**OXFORDSHIRE COUNTY COUNCIL'S RESPONSE TO CONSULTATION ON THE  
FOLLOWING DEVELOPMENT PROPOSAL**

**Application no:** 14/00702/REM

**Proposal:** Approval of reserved matters pursuant to Outline permission 05/01337/OUT - Proposed spine road.

**Location:** Land North East Of Oxford Road West Of Oxford Canal And East Of Bankside Banbury

DRAWING TITLE: **SPINE ROAD PROFILE CHAINAGE 0.000 TO 300.000 SHEET 1 OF 3**

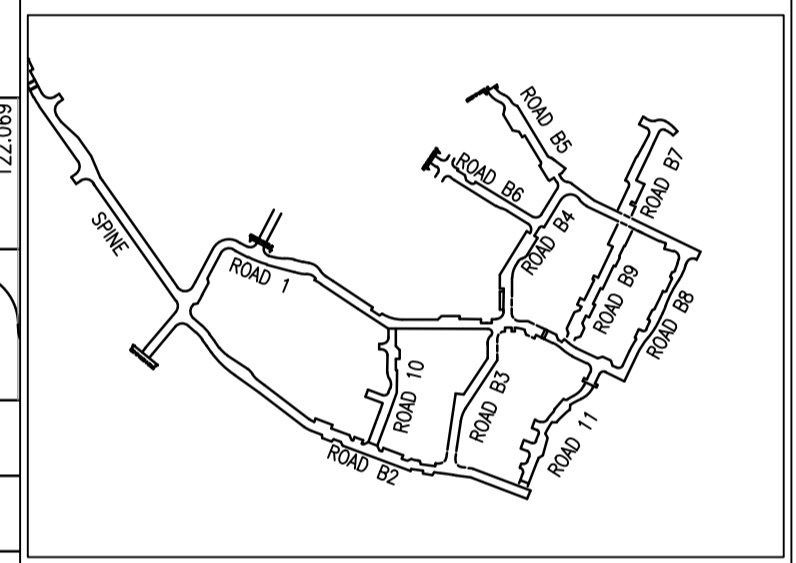
The re-submitted MEC drawings for the Spine Road's general arrangement do not appear to have been considered the list of items previously raised by the Local Highway Authority for the proposed spine road, such as:

- The submitted drawings do not provide any details of where future junctions serving future parcels are to be located;

- Unclear if any future direct access arrangements proposed for grouped properties?
- No traffic calming features are shown (design code requirement);
- No scaled vehicle (bus, refuse etc) swept paths have been submitted;
- No sight lines are shown for junction sight lines or forward visibility;
- No indicative details of parcels adjacent the spine road;
- No pedestrian crossing points indicated;
- No indication of bus stop arrangements along spine road;
- No tree types shown or specific locations. This is a safety concern as will affect future street lighting design;
- Unclear if spine road is in line with required road width (6m with localised variation and 2m footways on each side);
